Current Zoning: UR-C(CD) (urban residential-commercial, conditional) and ML-2 (manufacturing and logistics-2)
Proposed Zoning: UR-C(CD) SPA (urban residential-commercial, conditional, site plan amendment)

Approximately 1.32 acres located along the west side of Seigle Avenue and east side of Van Every Street, south of Belmont Avenue.

The petition proposes to amend an approved replan to modify the rezoning boundary, reduce the number of residential units, increase non-residential square footage, establish a project phase line, removes language pertaining to the 100-foot rail corridor, and add language pertaining to surface water management.

Skyline Townes
Rezoning Site Plan
 955 Seigle Avenue Charlotte, North Carolina

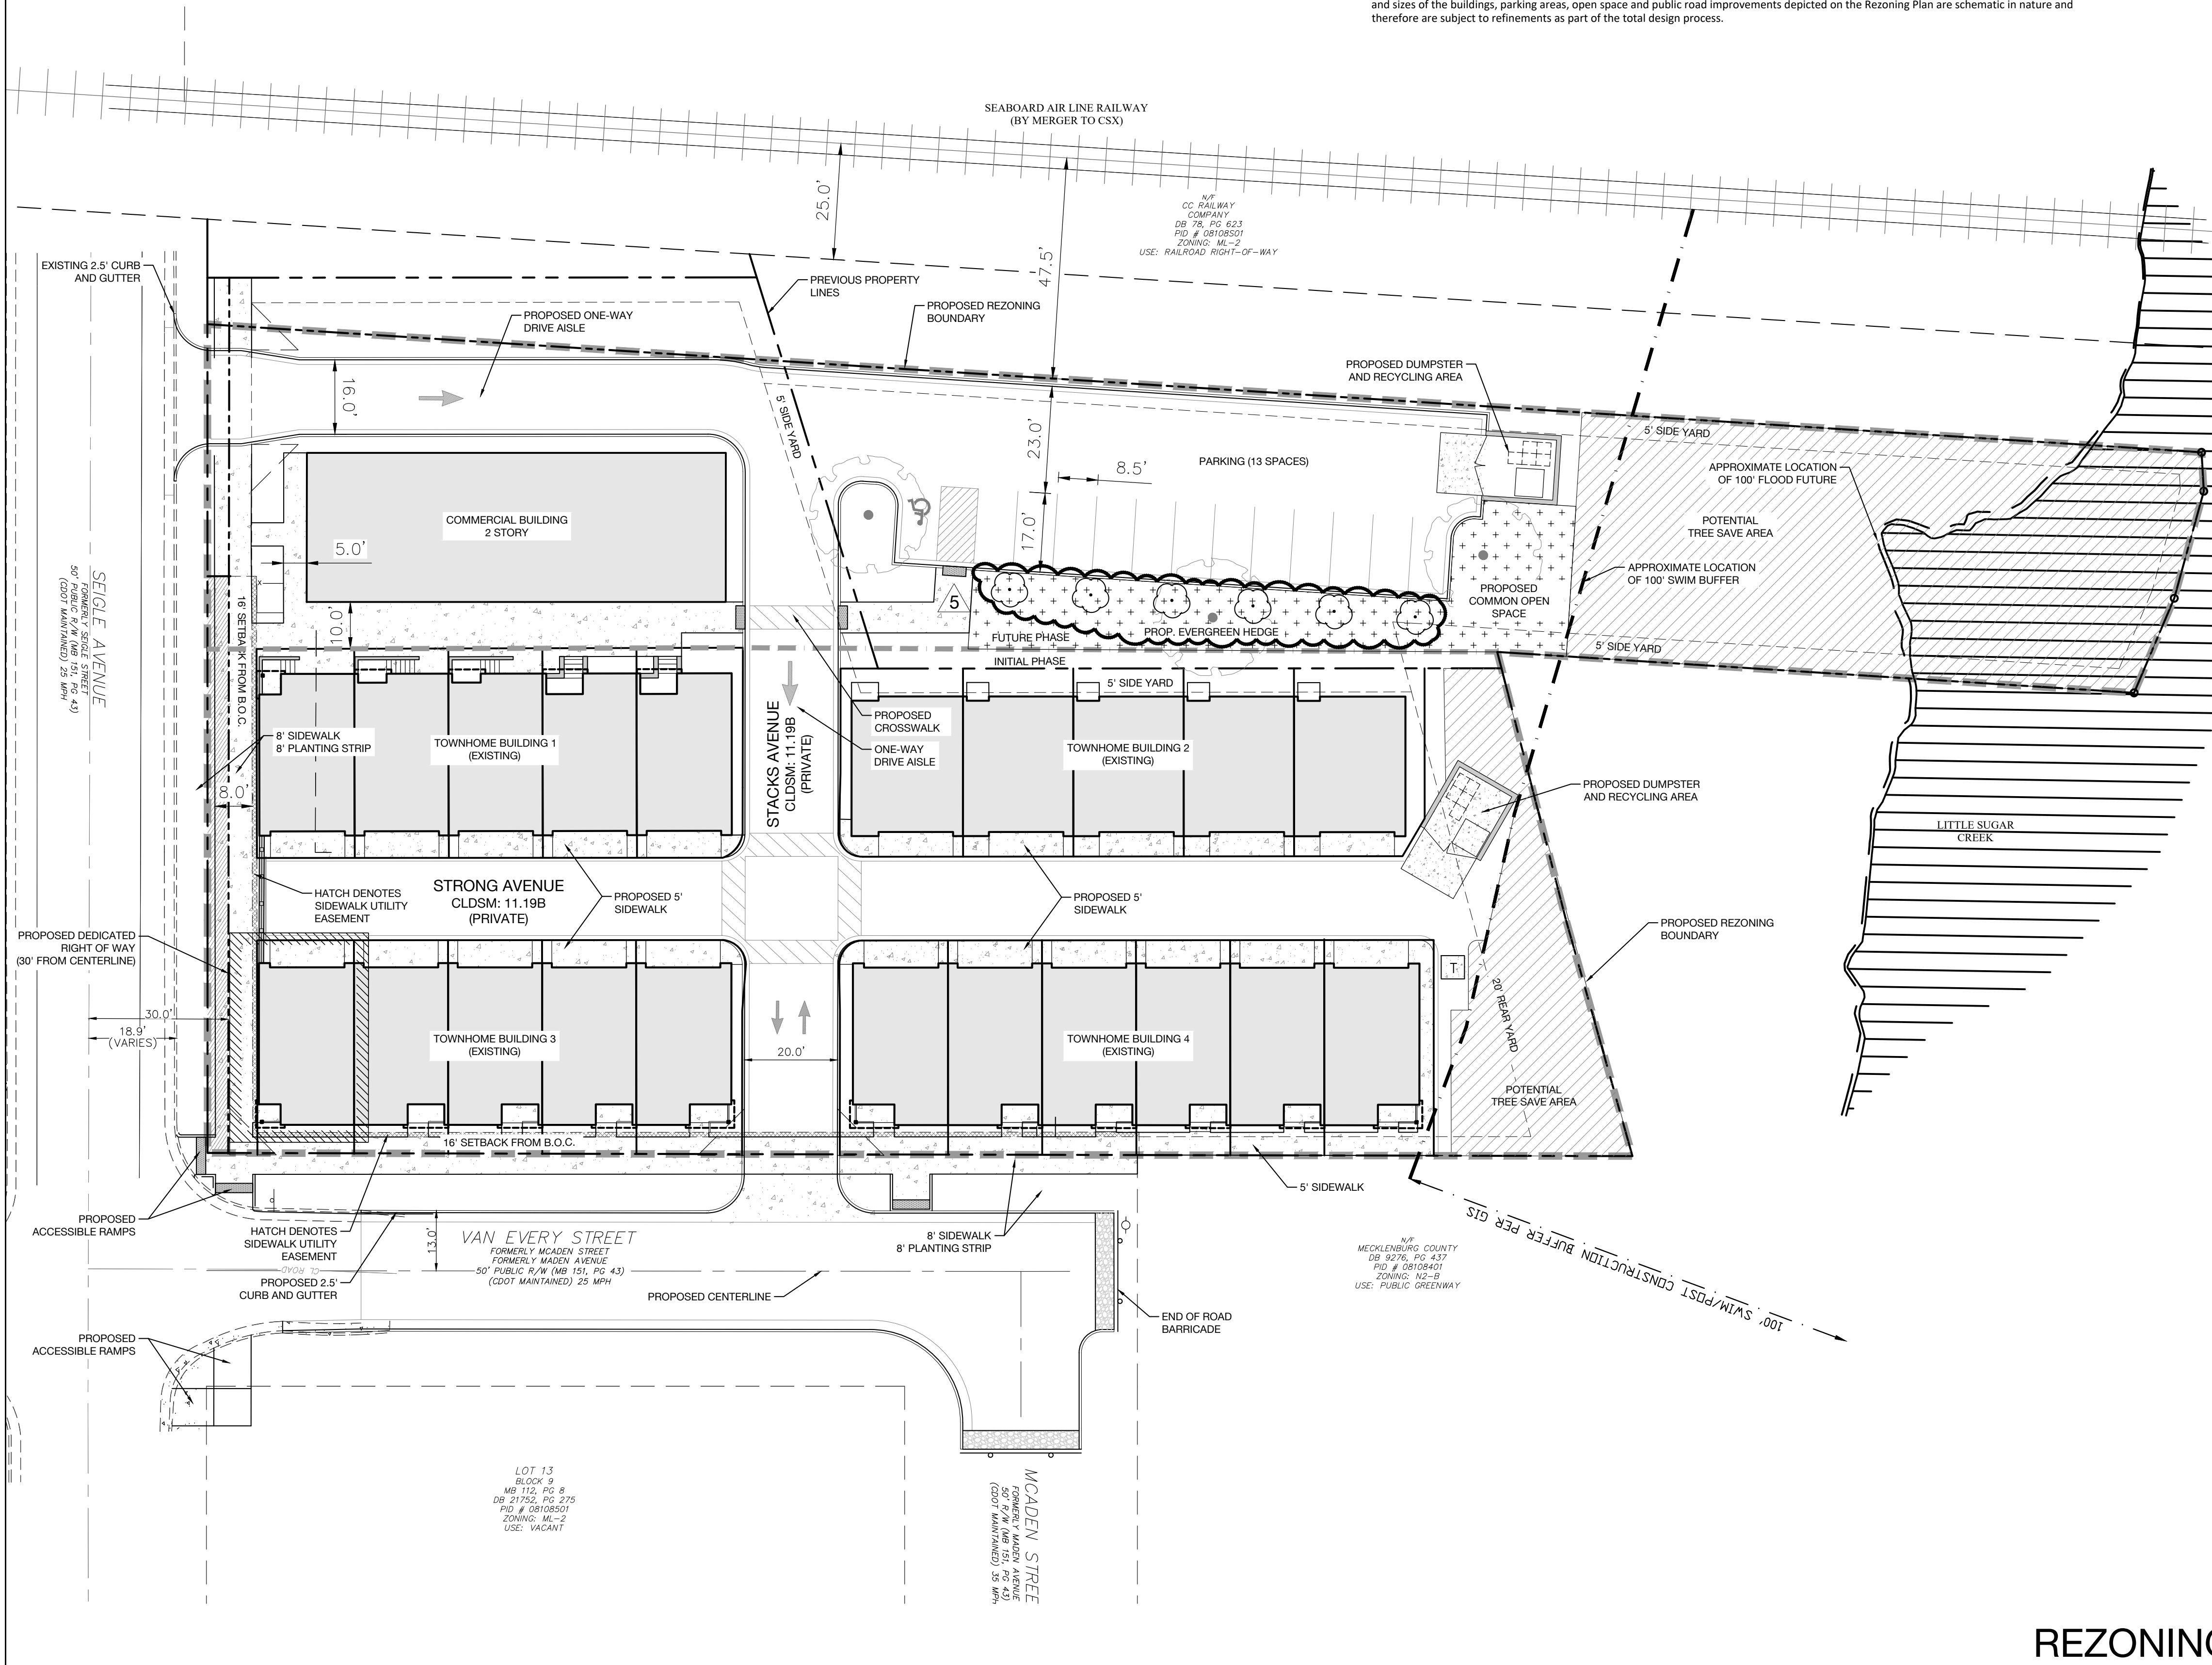
- **Mecklenburg County Parks and Recreation Department:** No outstanding issues.
- **Stormwater Services Land Development Engineering:** Buffer is to be measured from field-located top of bank of stream, not as shown on GIS. Please verify. See advisory comments at www.rezoning.org

- ~~1. There is a discrepancy on the site plan with regard to acreage. Site Development Data specifies 1.32 acres while General Provisions Note 1 specifies 1.27 acres.~~
- ~~2. Parking lots for more than 10 automotive vehicles and parking decks, excluding new and used automotive sales lots and parking areas for detached, duplex, triplex or quadraplex dwellings on a single lot; (Ref. Sec. 12.303). This will be applicable to parking area abutting railroad right of way. In addition, petitioner should consider screening commercial parking area from residential units.~~ Addressed.
- ~~3. Please confirm vicinity map matches rezoning boundary modification.~~
- ~~4. Please confirm Architectural and Design Standards Note 3.a as Permitted Uses Note 1.a states the existing building will be demolished.~~

- ~~5. Show tree save calculations. Any tree save that is being replanted must be done at 150%.~~
~~Update:~~ Missing calculations and numbers do not appear to be accurate. Addressed.

- **Notes that replanted tree save will be done at 150% as required by ordinance.**
- **Illustrates proposed evergreen hedge between commercial parking area and residential units.**
